Broken Hill City Council

February 25, 2014

Submission in relation to EA modification Rasp Mine PA 07_0018 Mod 2

**Figure 5.1**

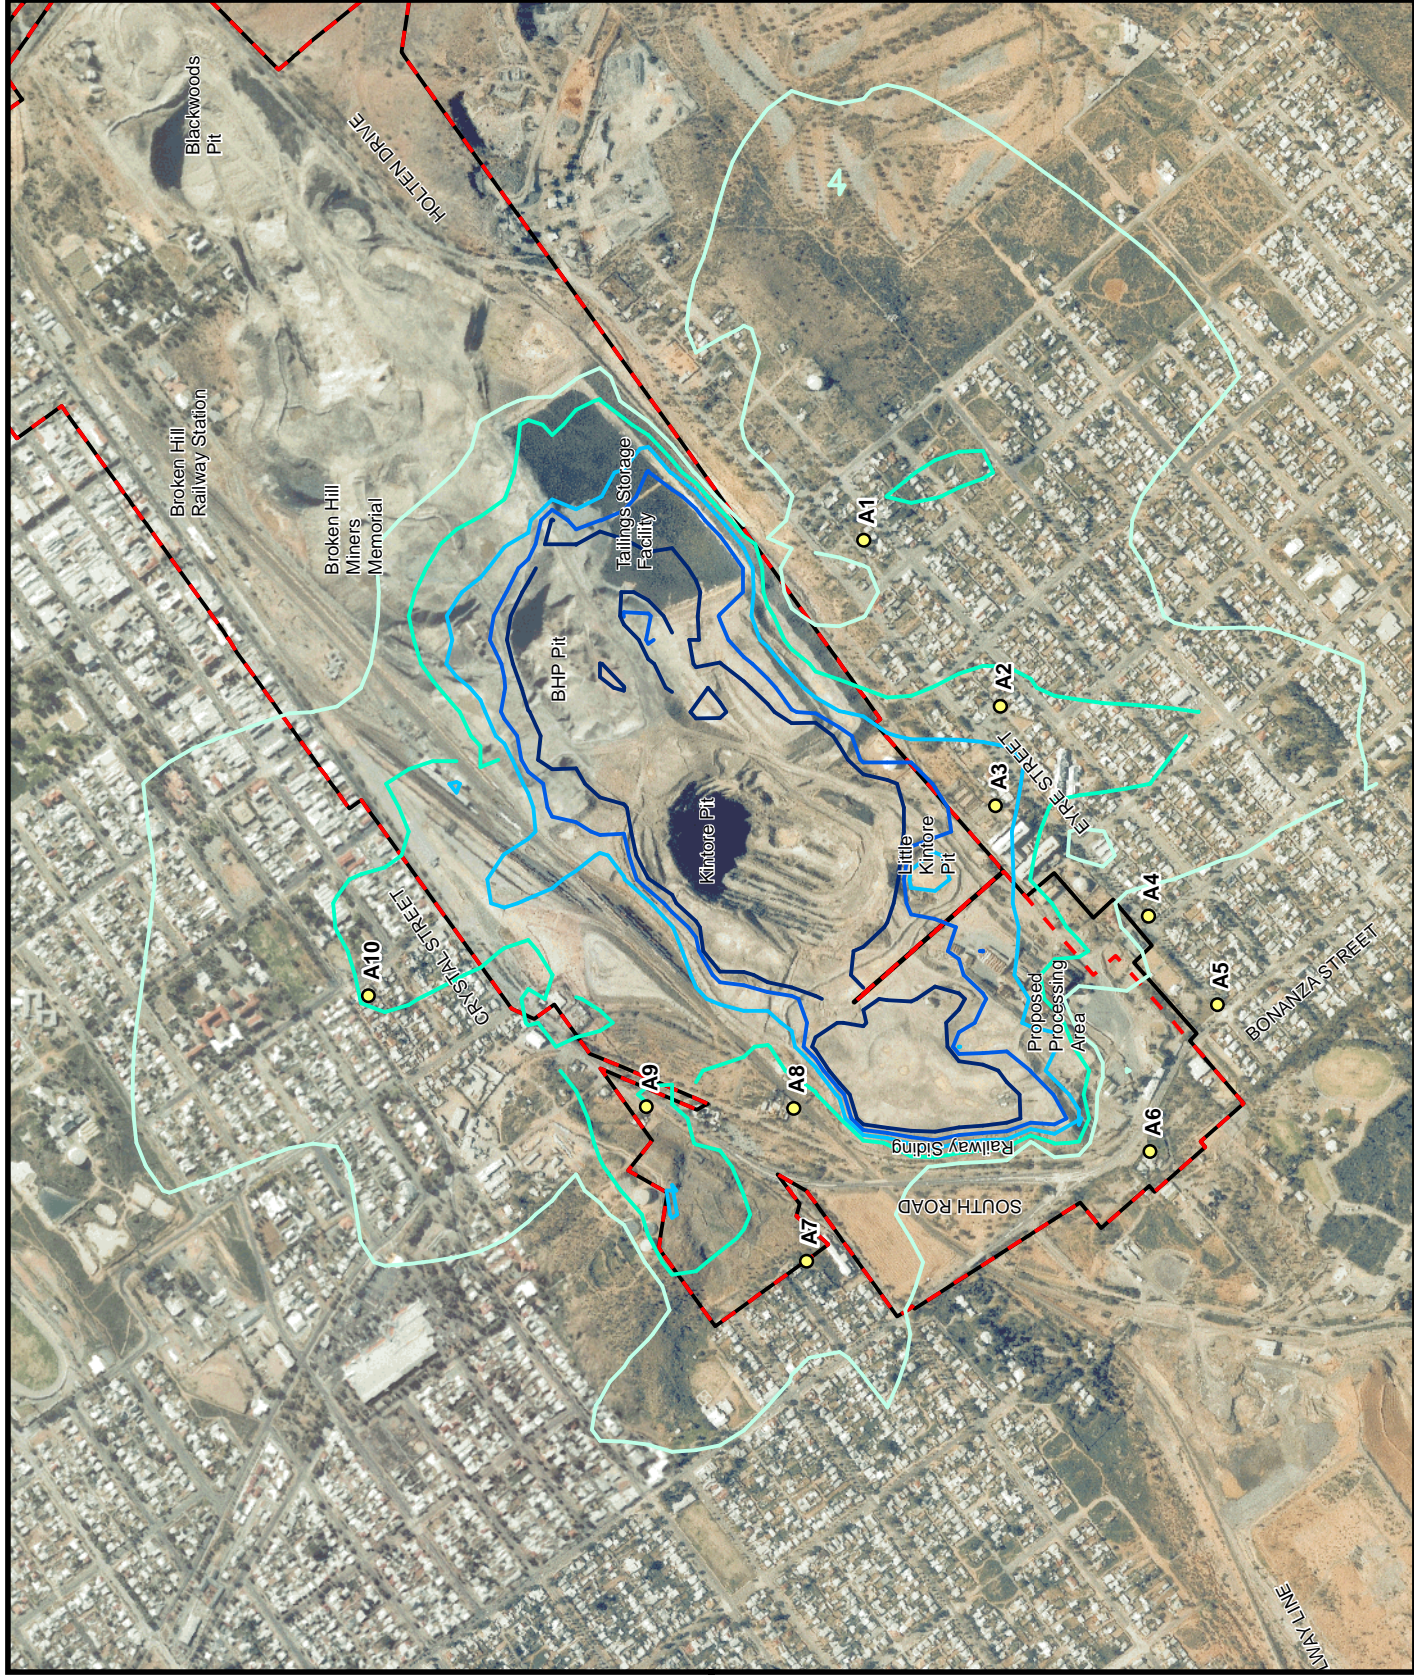
It is noted that the filtration shed has been excluded from the results and predictions. Concerns are raised in relation to the potential cumulative impacts of inclusion of this noise source. It would also appear that the residences in Proprietary Square have not been considered in this assessment and concerns are raised in relation to the impacts on these residences and the residences located in Crystal St and Argent Lane which are included within the 40 dB(A) contour.
